23 June 2025

Arrangements for Handling Heritage Applications Direction 2021

MONKS HOUSE, BOURNE ROAD, SPALDING, LINCOLNSHIRE Application No. H16-0526-25

PLANNING			
PROJECT TITLE:		MONK'S HOUSE	
DRAWING TITLE:		FIRST FLOOR PLANS	
DRAWING NO:	REVISION:	PAGE SIZE:	SCALE:
2548-PP02	A	A3	1:100

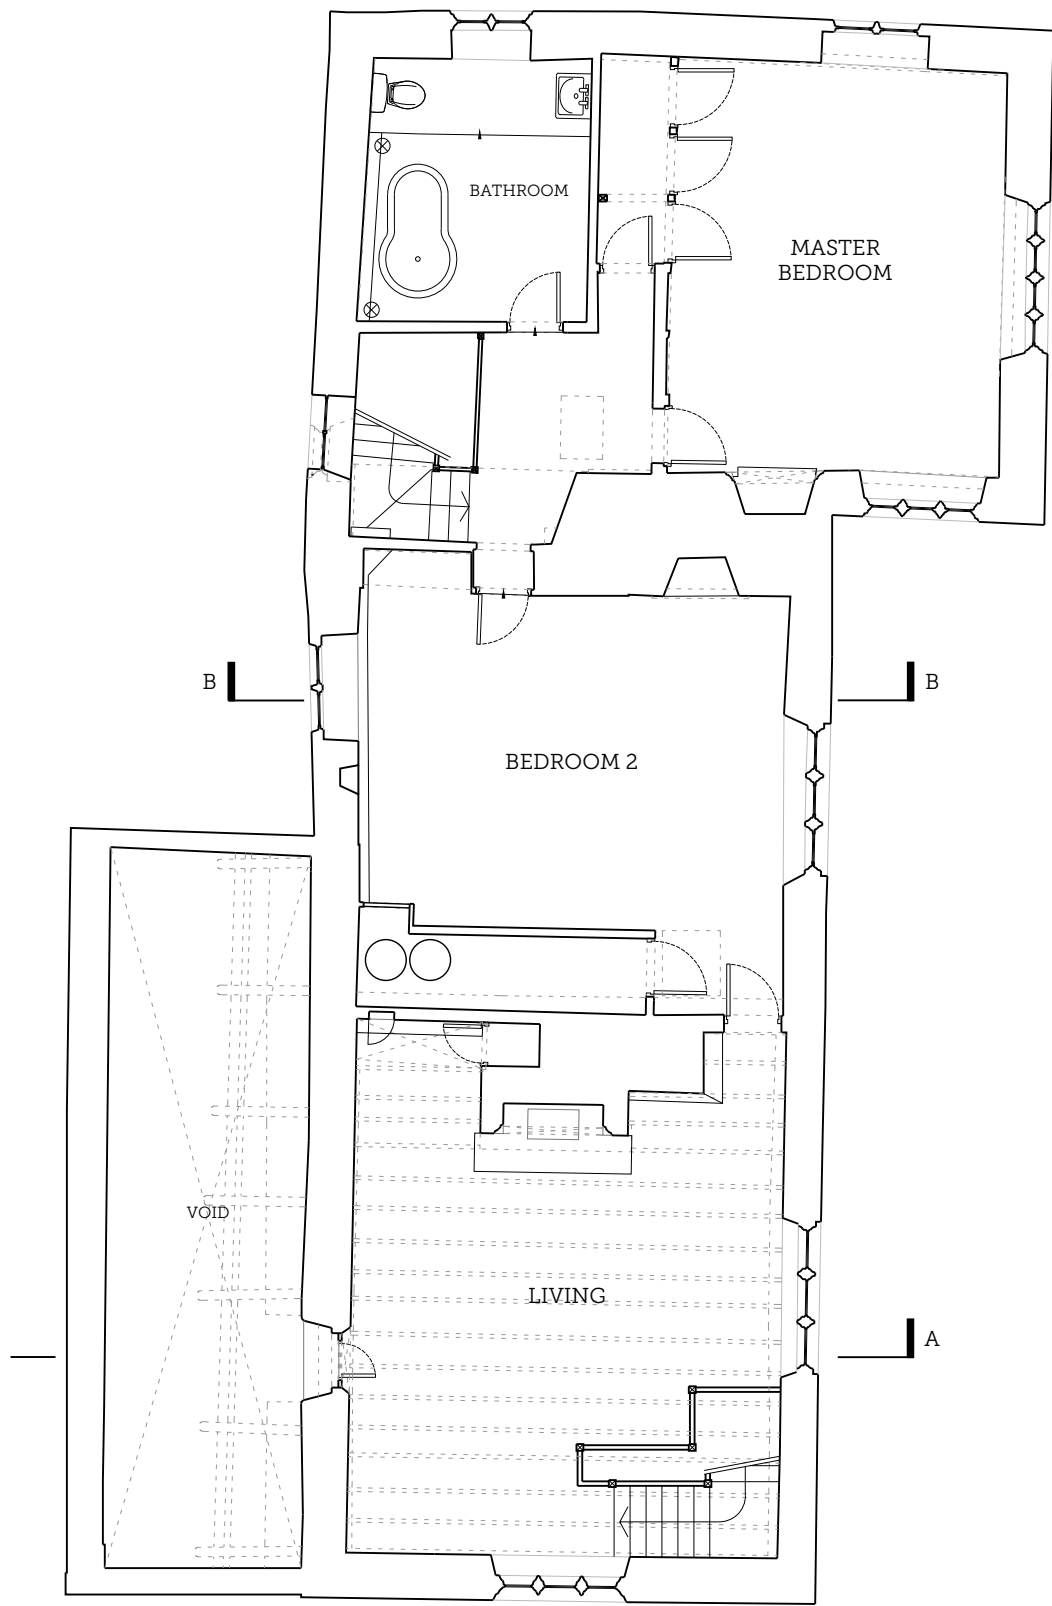
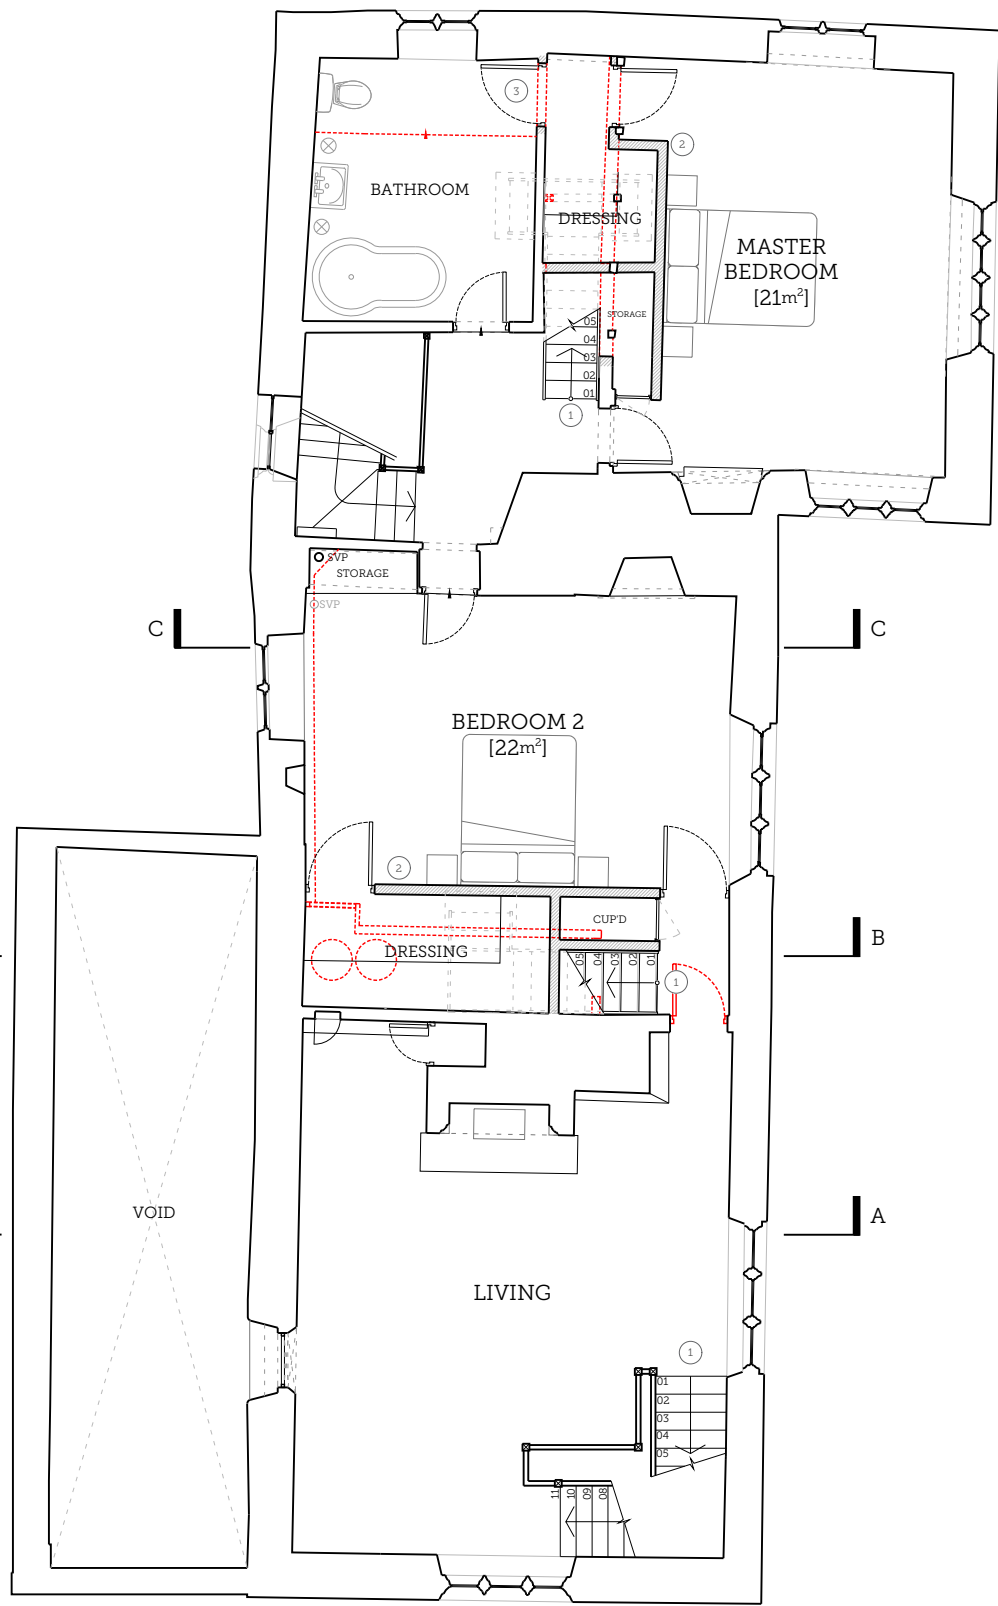
The application seeks to introduce three new staircases to facilitate loft access. As mentioned in our previous advice (of 22 April 2025) further detail is needed regarding proposed works to install the new staircases. The Heritage Impact Assessment states that 'the proposed adaptions to the first floor are relatively simple with seemingly no loss of historic fabric', however no details are provided. Without this detail, the installation of the three staircases has the potential to cause harm to the significance of the listed building. Detail should be provided of the proposed three new staircase installations to allow the LPA to properly assess potential impacts.

PROJECT TITLE: MONK'S HOUSE				SCORER HAWKINS ARCHITECTS Lodge Farm Barns Skendleby, Spilsby Lincolnshire, PE23 4QF 01754 890089 projects@scorerhawkins.co.uk www.scorerhawkins.co.uk
DRAWING TITLE: LOFT PLANS				
DRAWING NO: 2548-PP03	REVISION: A	PAGE SIZE: A3	SCALE: 1:100

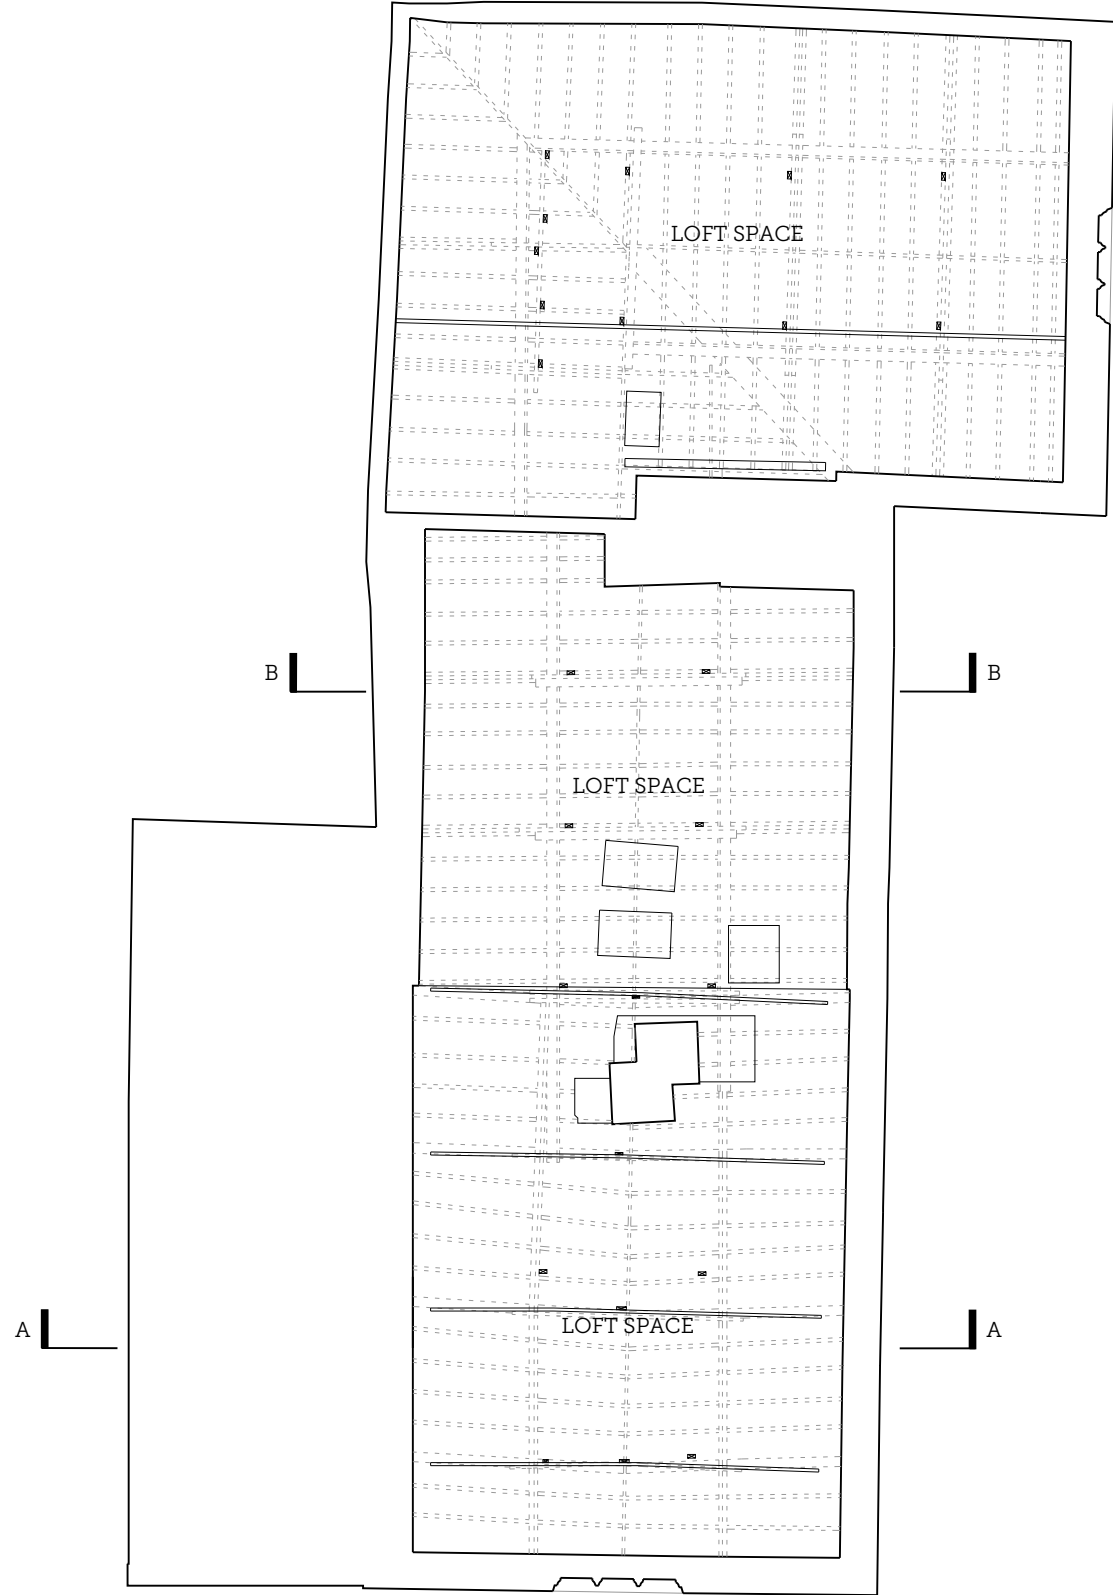
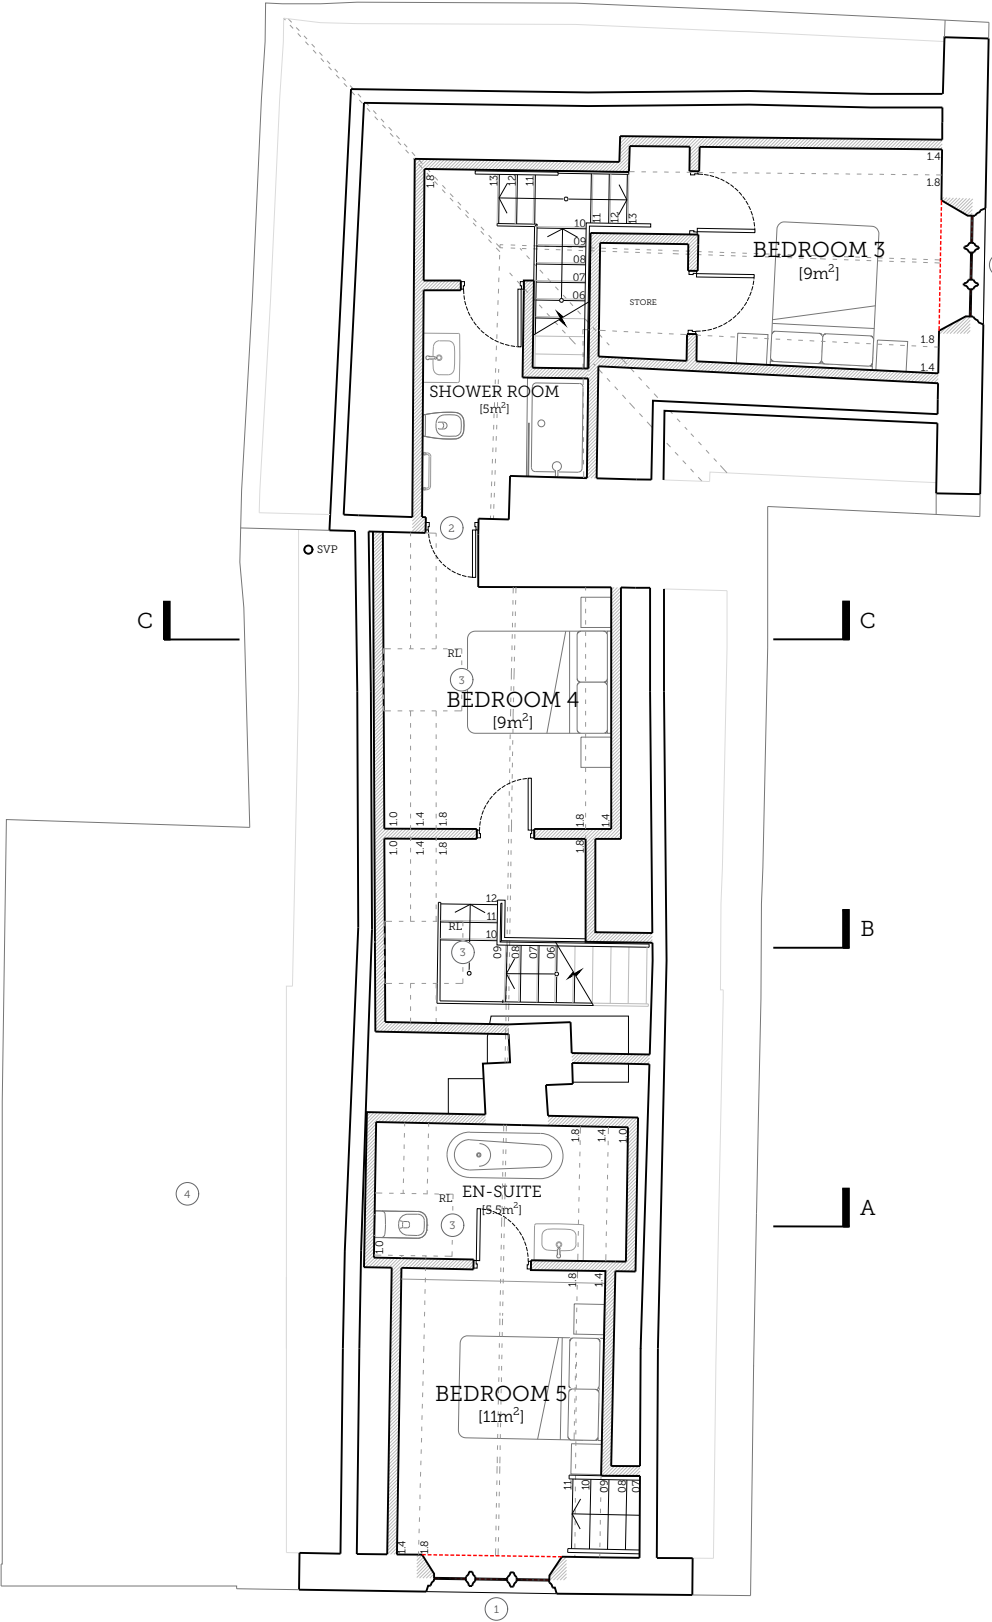
The application also seeks to install three rooflights to the west-facing roof slope. At present no details of the proposed rooflights have been provided, therefore they have the potential to cause harm to significance. Sufficient detail should be provided including the size, specification, material and colour of the proposed roof lights, in order to allow the LPA to make an informed impact assessment.
